DRAINAGE MEMO

LOT 1, SPACE VILLAGE FILING NO. 3

6809 SPACE VILLAGE AVENUE

PCD Project No. SP-17-009

DATE: 08/22/2018
 SHEET NUMBER: 10 OF 1

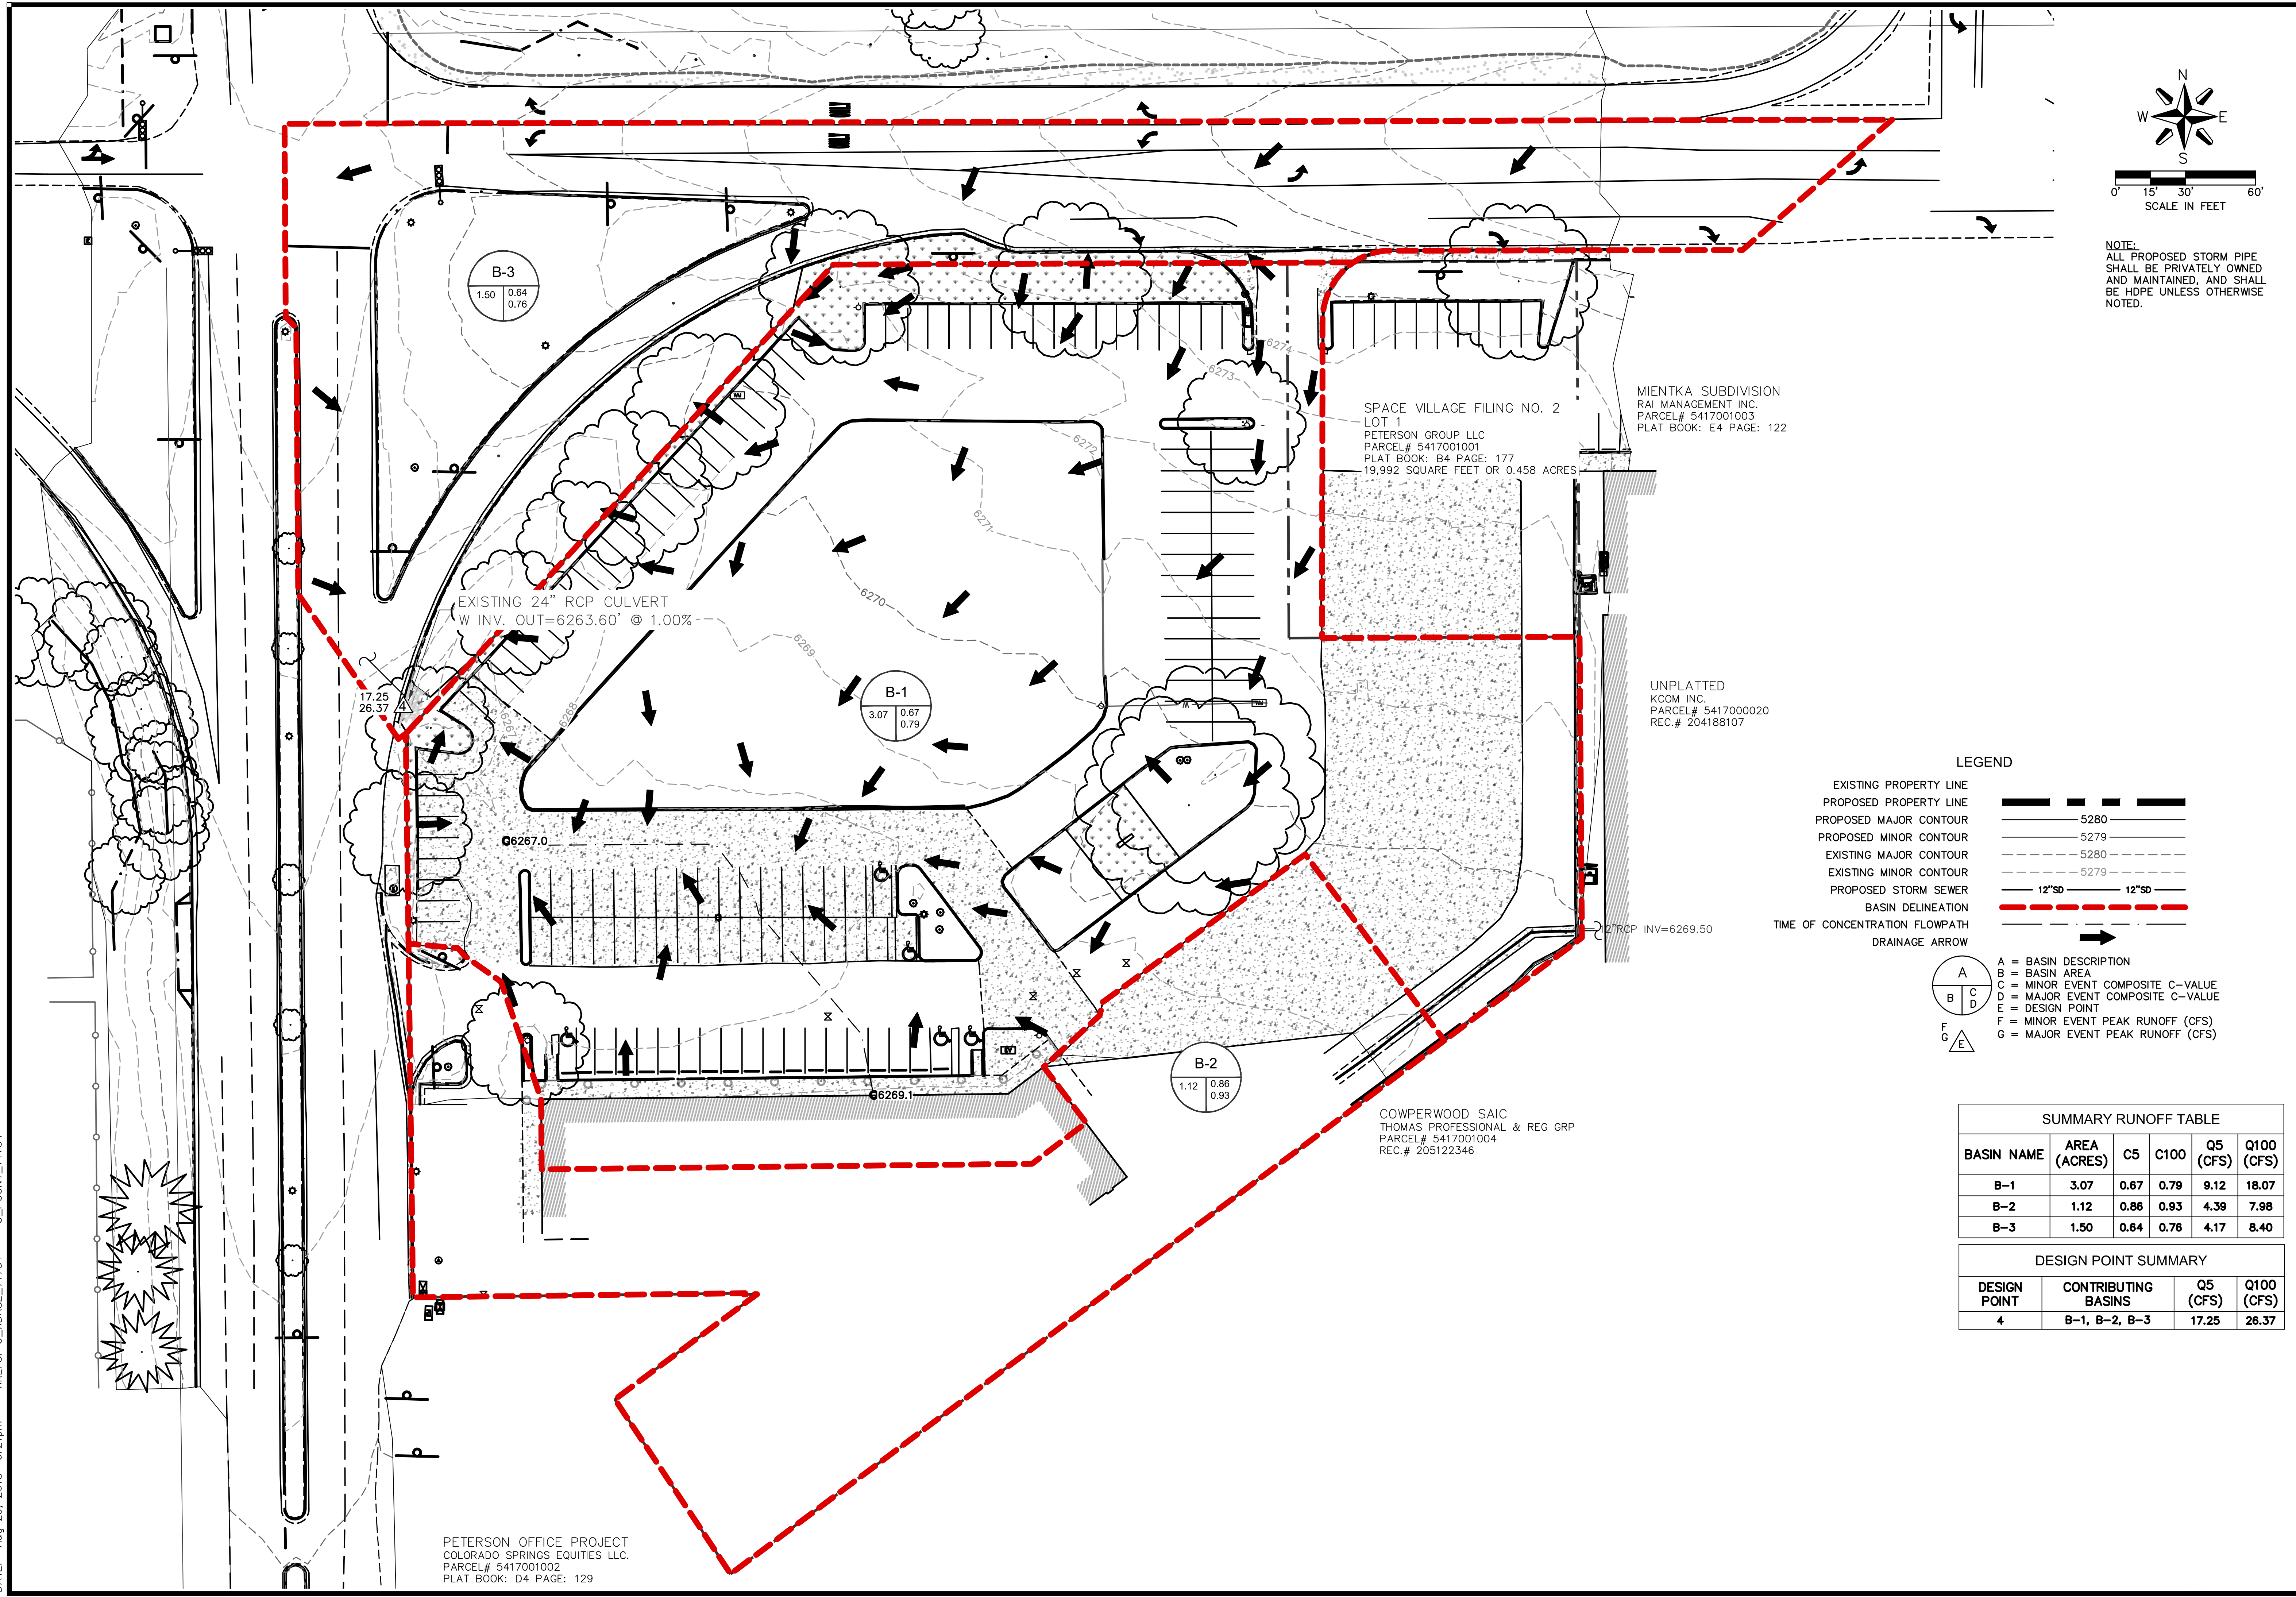
Update Basin Description. The majority of EX-2 is On-site

descriptions updated

DWG: F:\2017\1501-2000\017-1754-40-Design\Reports\GNCV\Drainage\Memo\AutoCAD\C_PBSN_71754.dwg
 DATE: Aug 29, 2018 6:20pm
 USER: jerrouspse

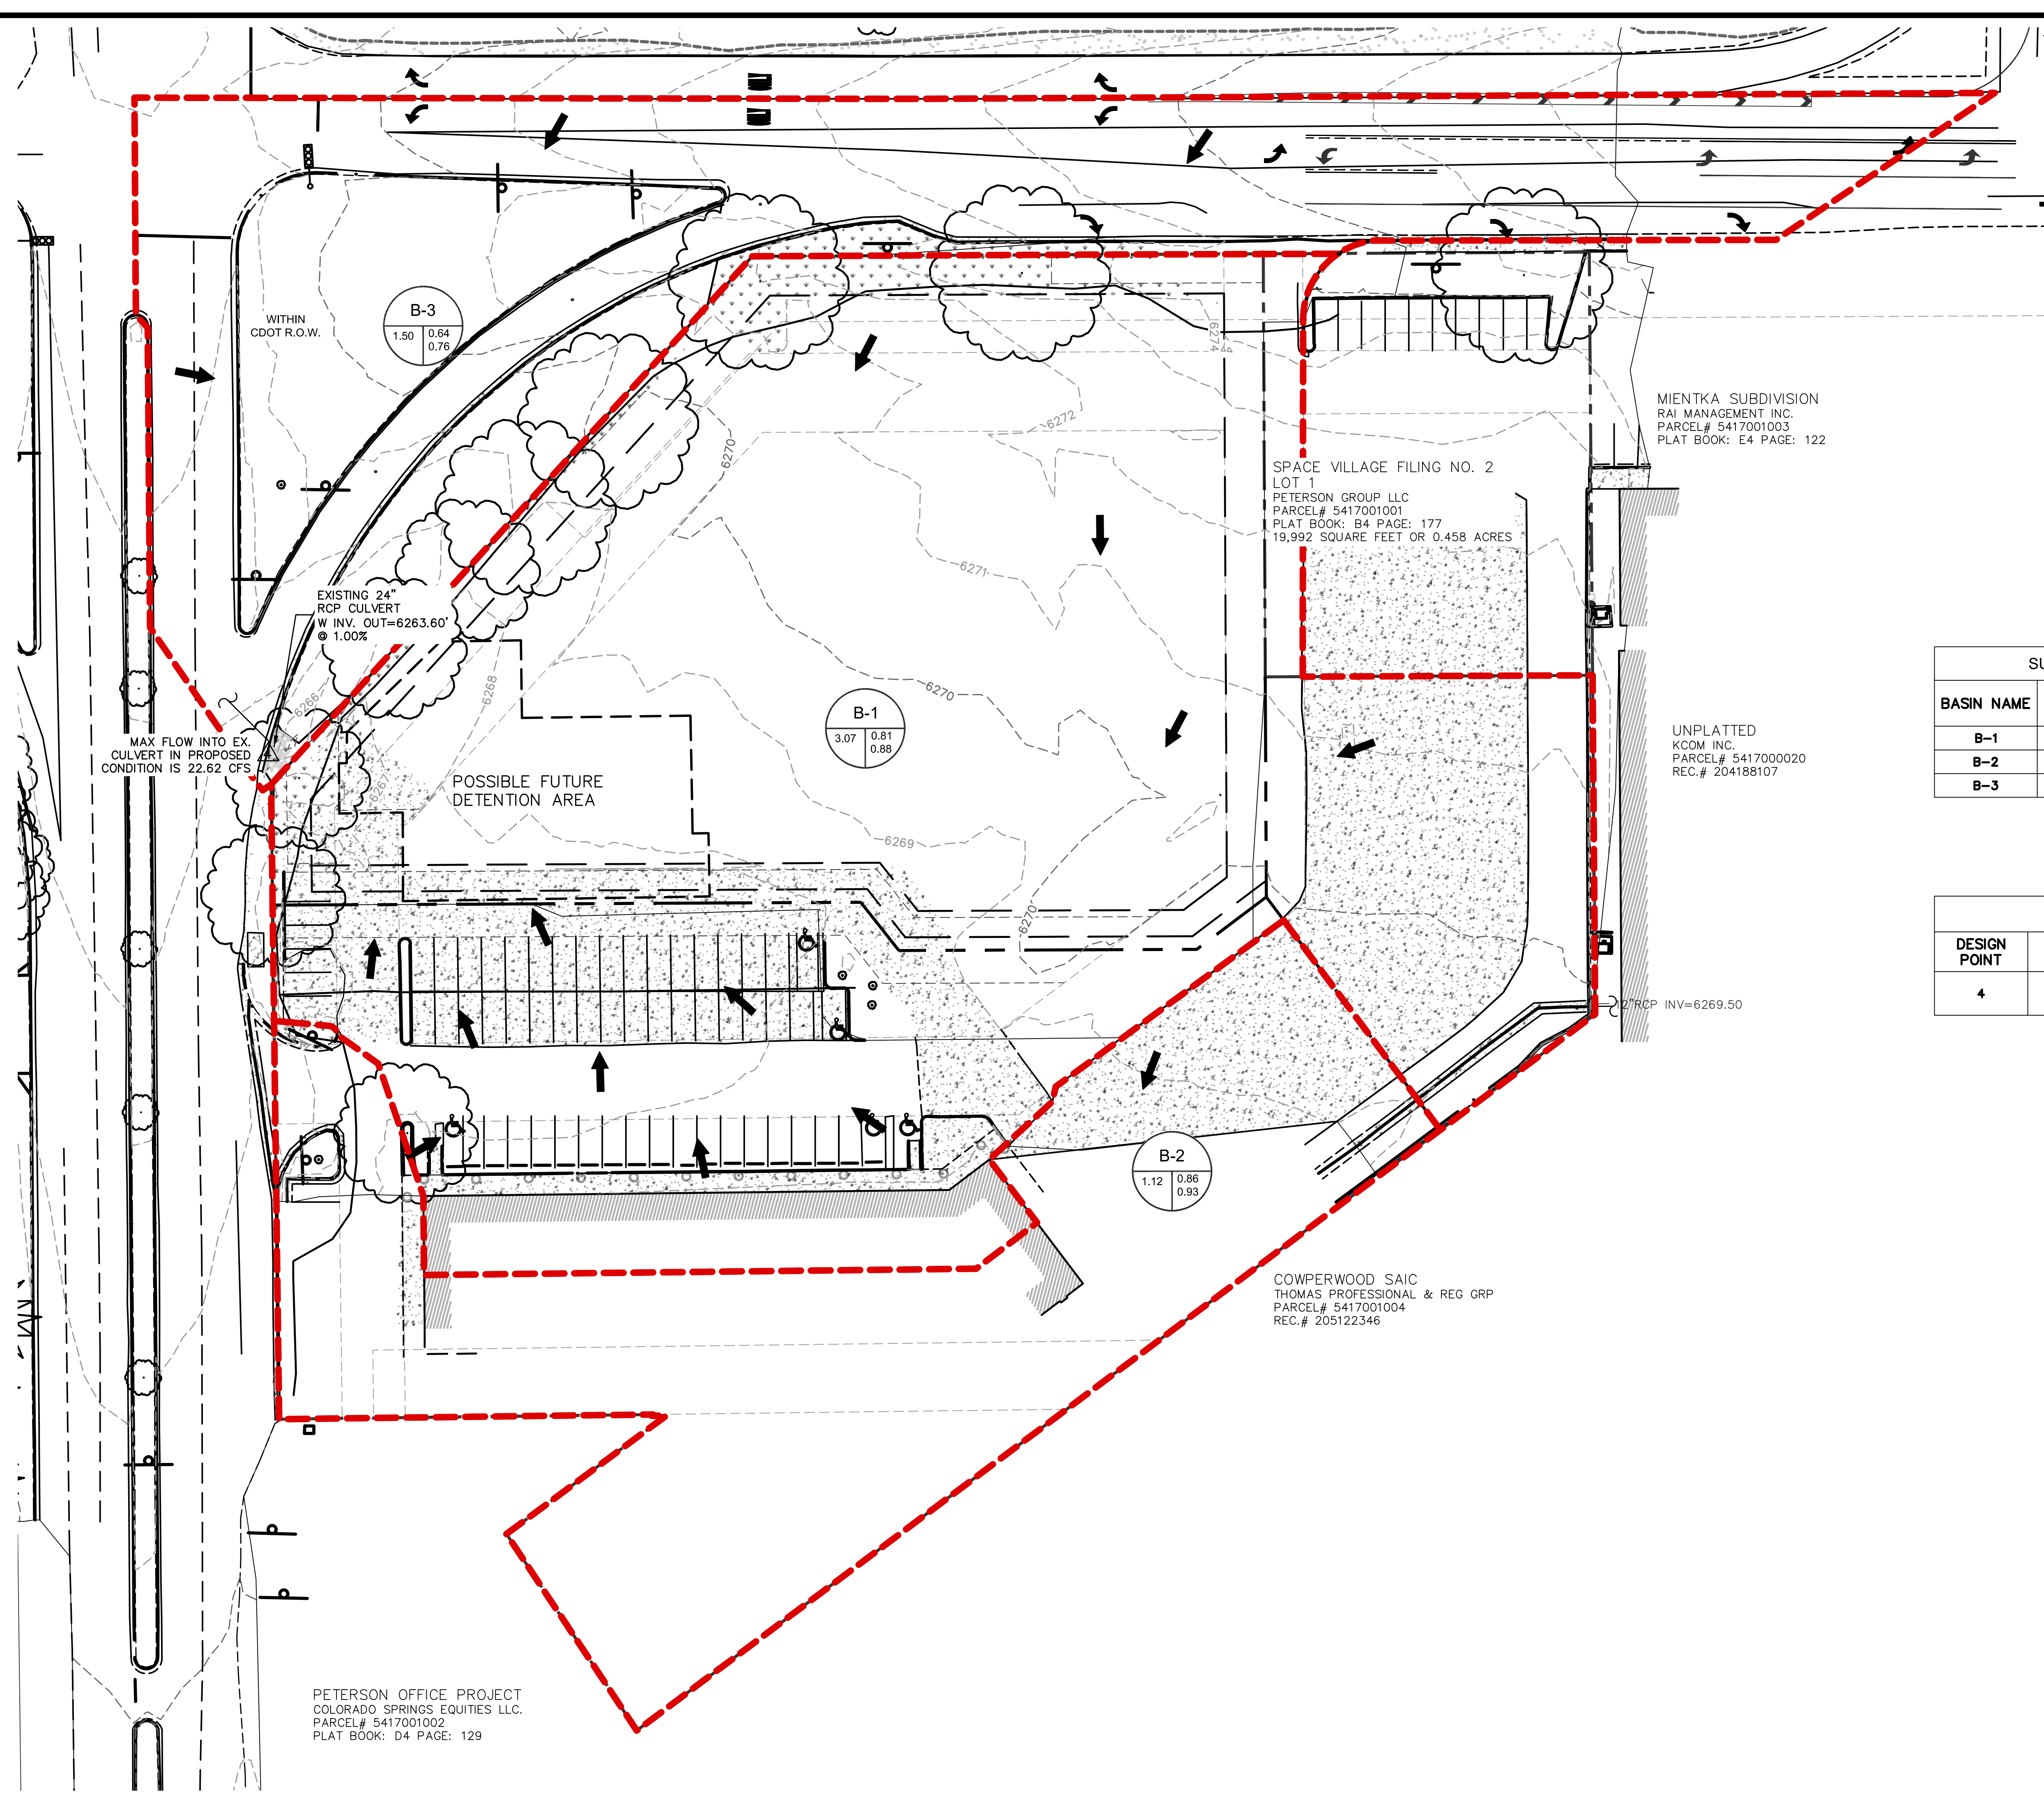
If the off-site flow is routed through the detention facility then the OS-1 area and imperviousness must be included in the detention pond sizing calculation or else the drainage conveyance design must by-pass the detention facility. Update the UD-Detention calculation and/or narrative accordingly.

Update the basin descriptions for OS-1 and B-1. Majority of OS-1 is within the subdivision. B-1 consist mainly of Lot 1, but not the entire site.

Narrative has been updated to include all of B-1 in the detention facility

basins and descriptions updated
